SDNP/22/02002/ADJAUT

Neighbouring Authority Consultation

Proposal: Adjoining Authority Consultation - Arun DC (AL/39/22/OUT) - Outline application with some matters reserved (appearance, landscape and scale) for the erection 9 No. residential dwellings.

Address: Land to South of Dukes Road , Fontwell , Arundel , BN18 0SP,

Drawing 221528/TS/01 – Proposed Access Arrangements

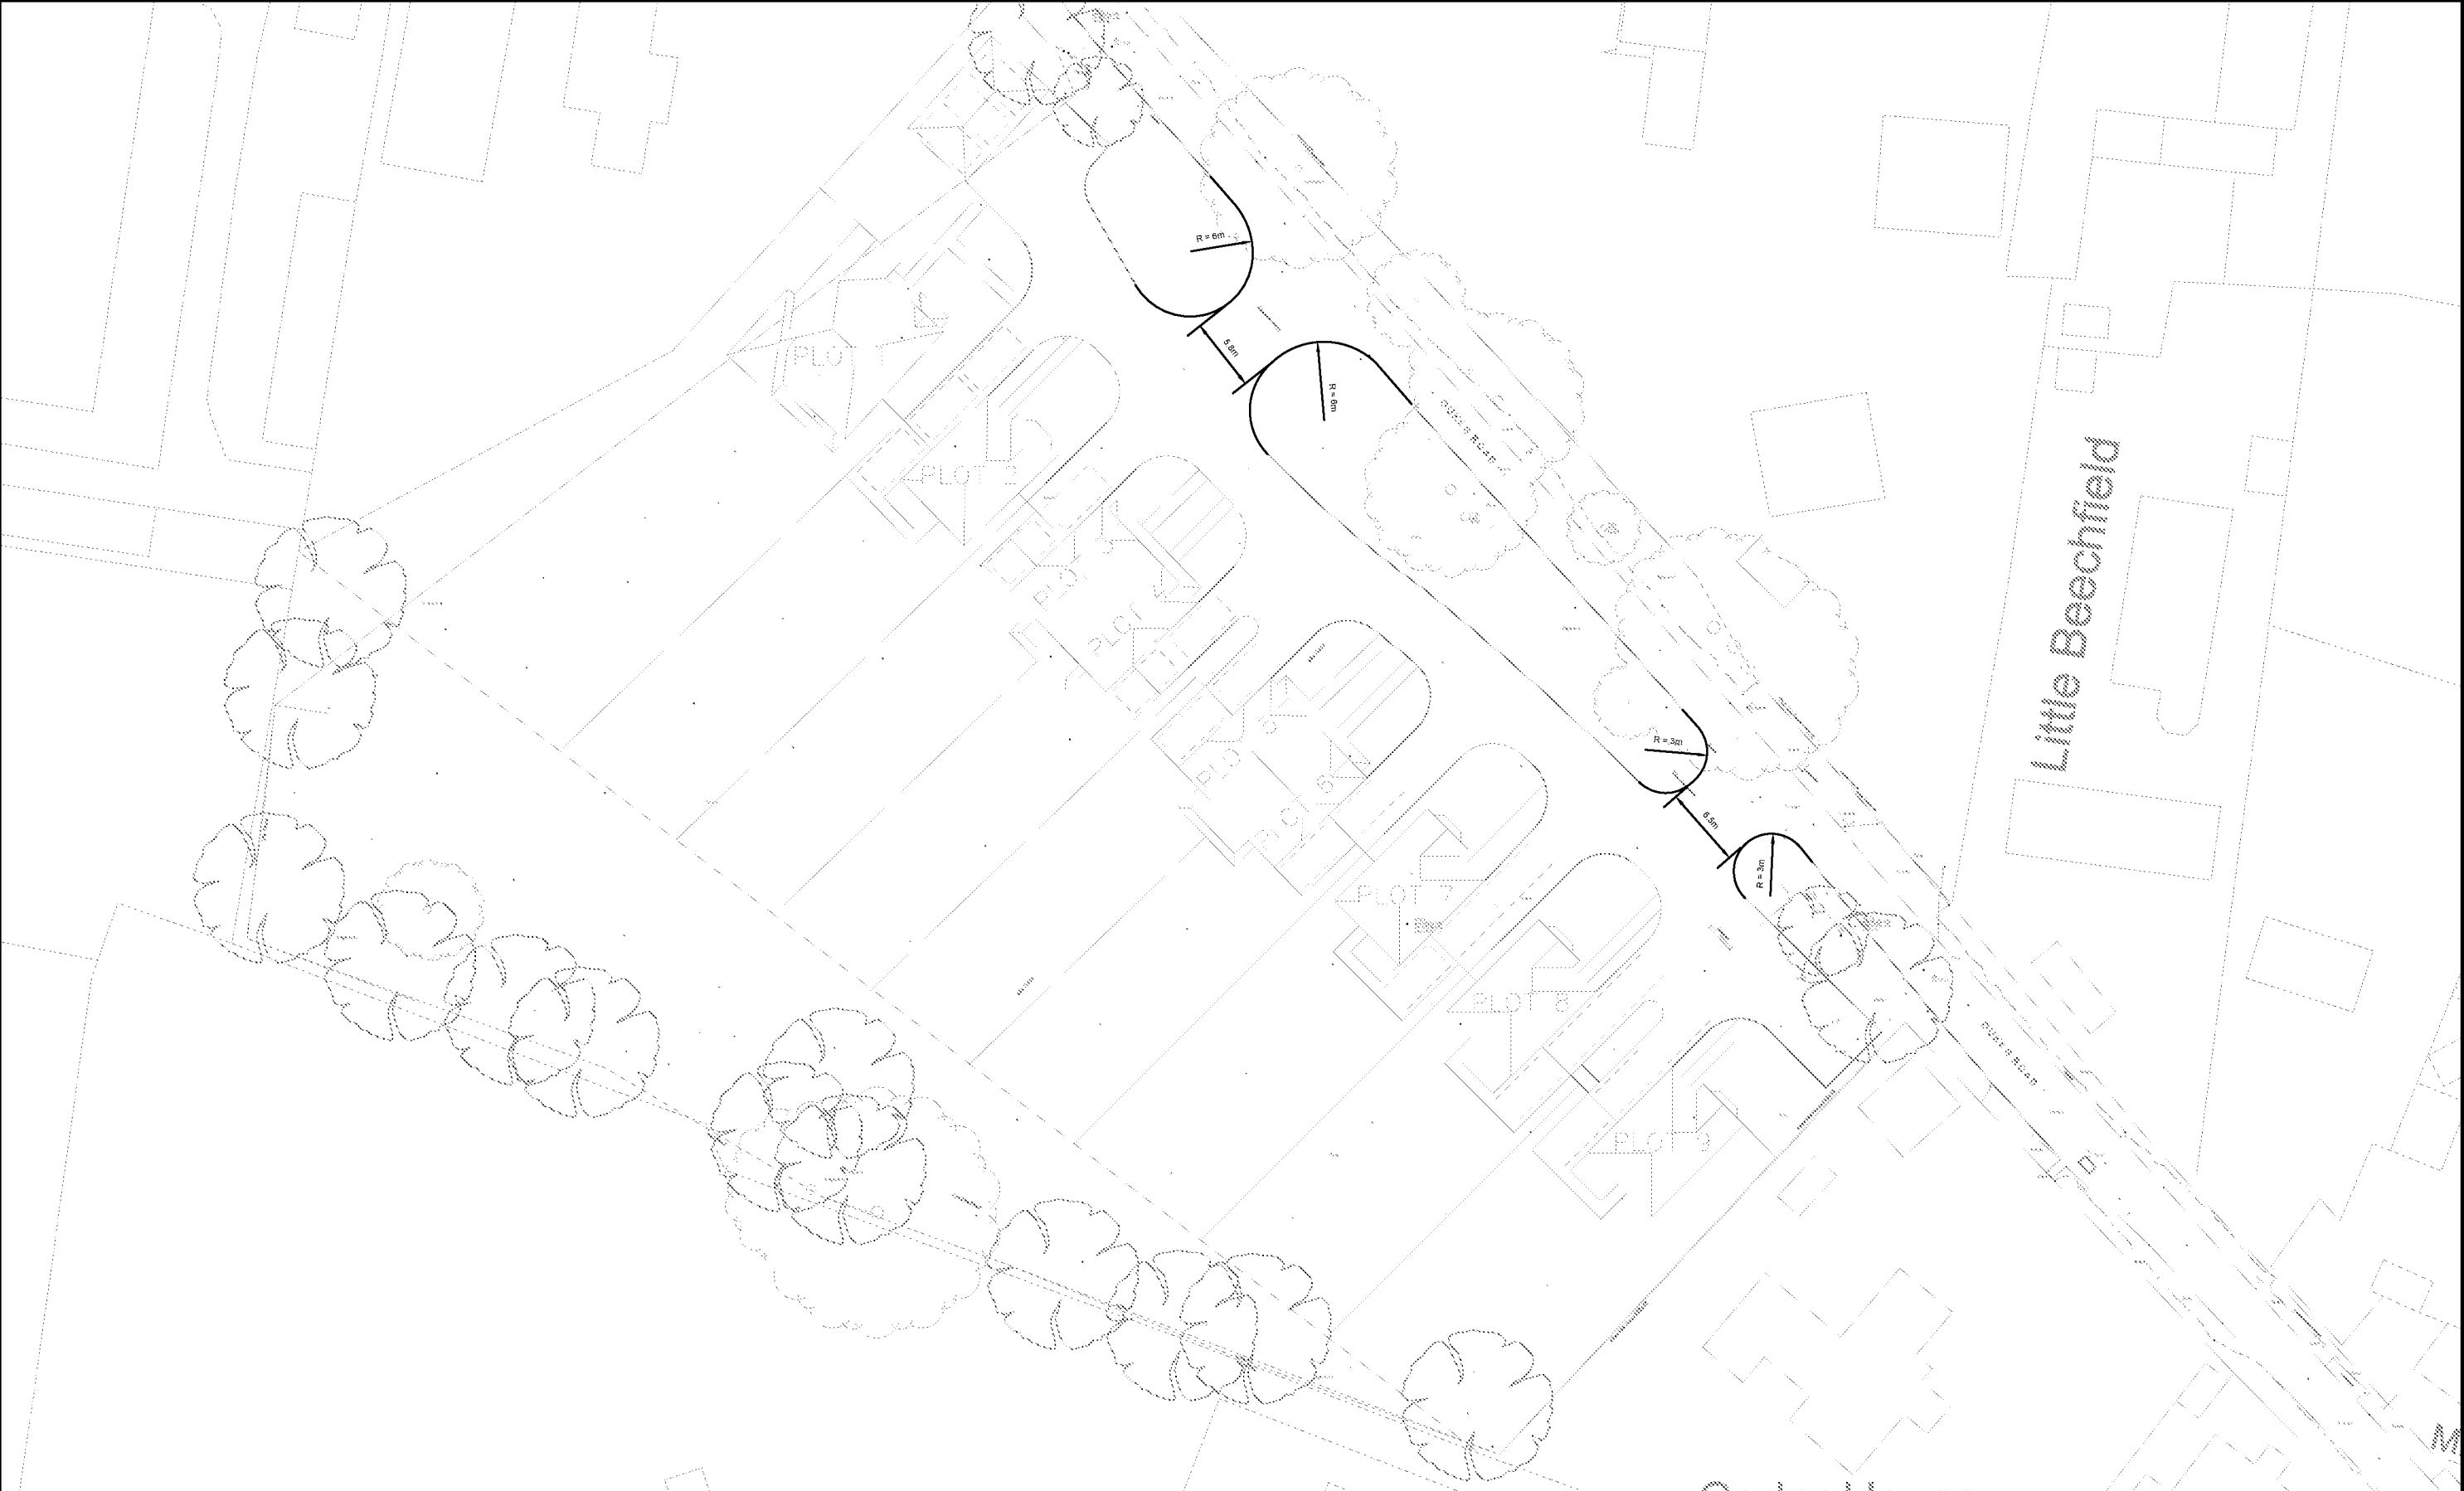
The proposed access to the site would see the implementation of a secondary route alongside Dukes Road with two entrances points for the 9 dwellings. It is considered this would not be in keeping with the rural nature of Dukes Road and add a level of urbanisation in such a rural area. Whilst this is an outline application to include access and layout (with appearance, landscaping and scale reserved) there are concerns about the amount of hardstanding due to the proposed access arrangement and visual impact upon the surrounding rural character.
